Application for a non-material amendment following a grant of planning permission.

Householder Planning Application - Erection of single storey side, front and rear extensions and creation of parking (following demolition of front porch, side extension and rear garden room)

Reference number:	<input type="text" value="DC/21/04413"/>
Date of decision	<input type="text" value="21/09/2021"/>

To remove and infill the opening of a redundant door on the front wall.

Proposed Front Elevation

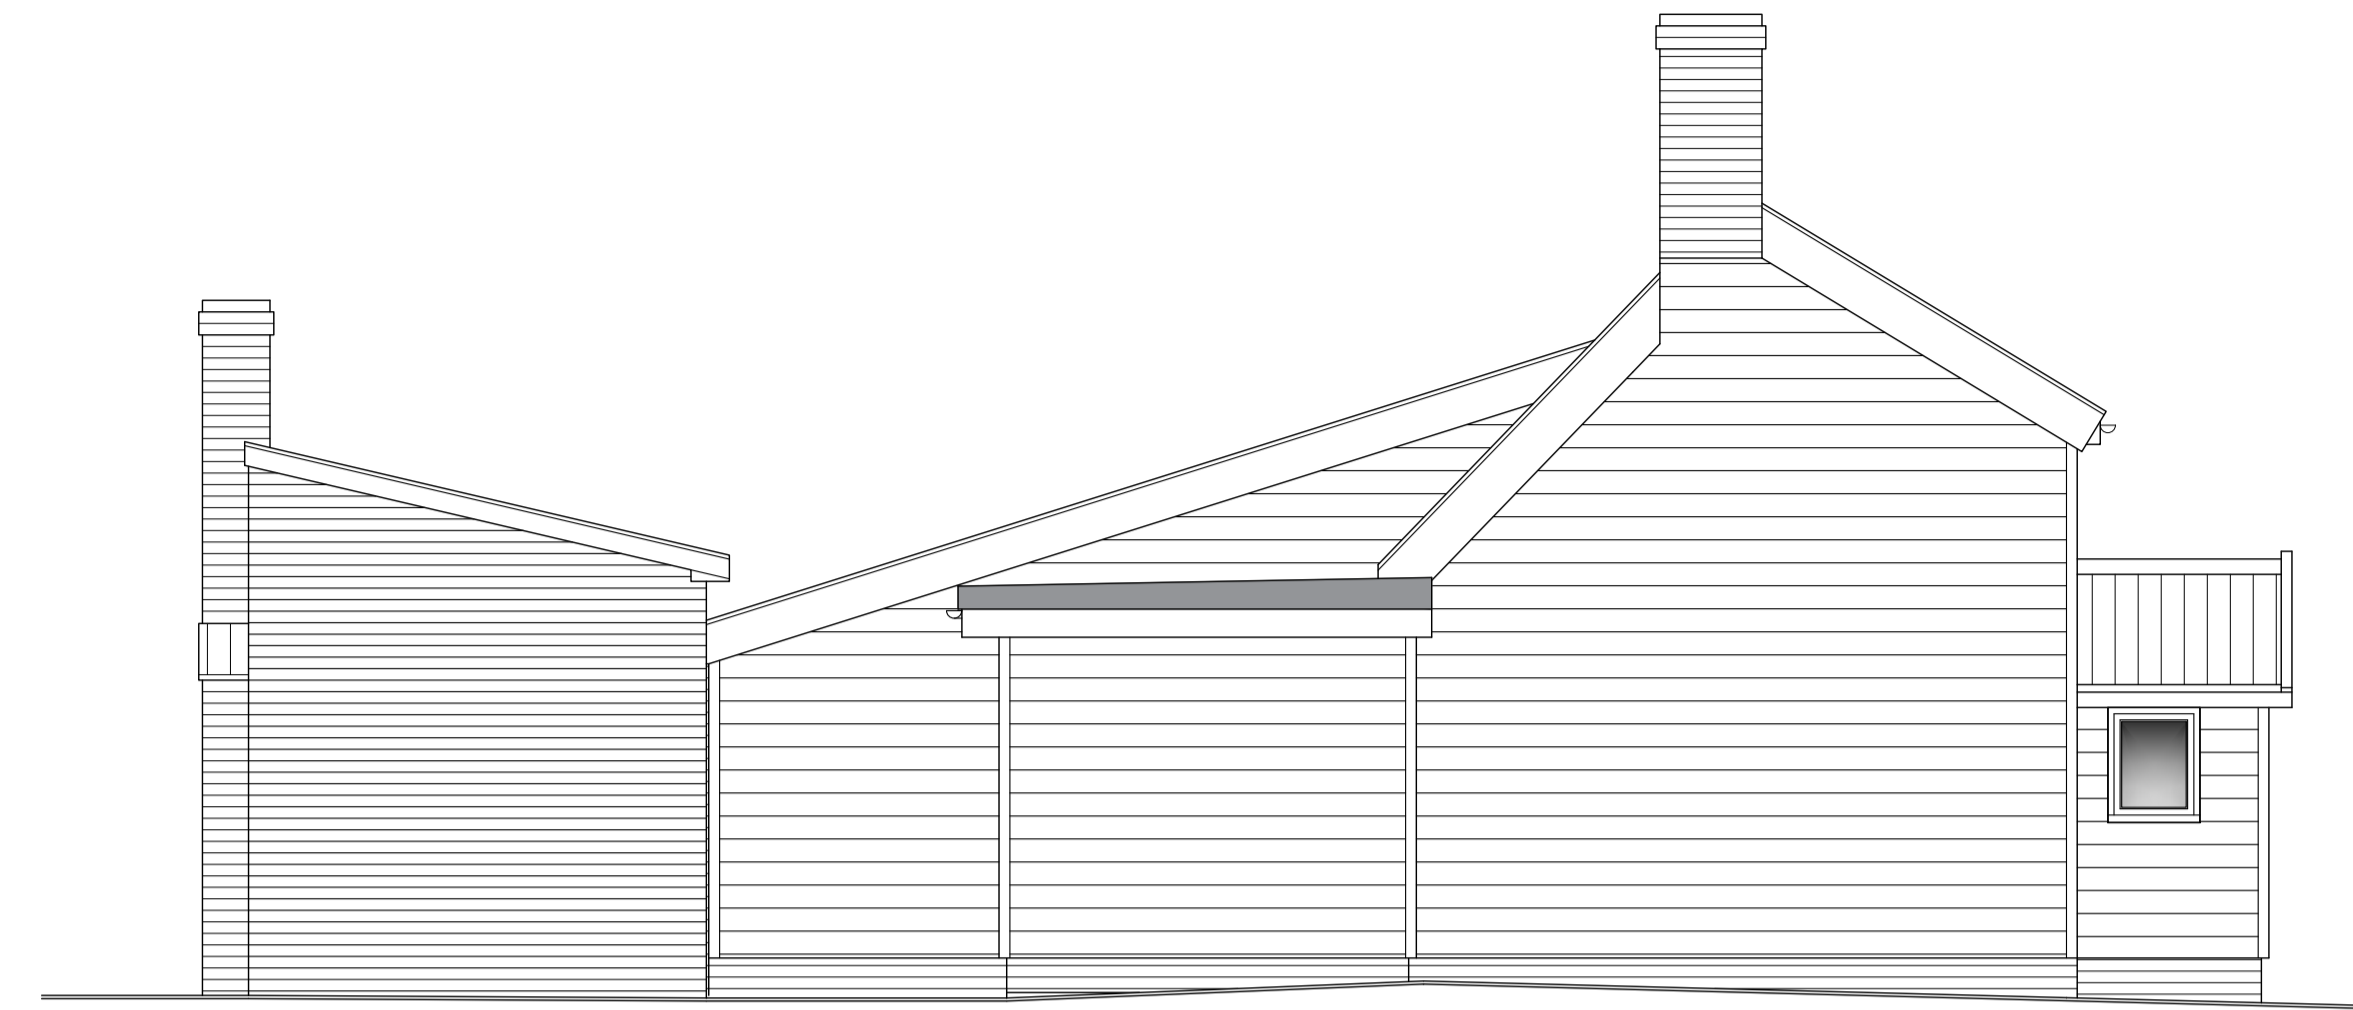
The front elevation would look confusing if the door were retained, better to remove and replace with painted brickwork to match the existing.
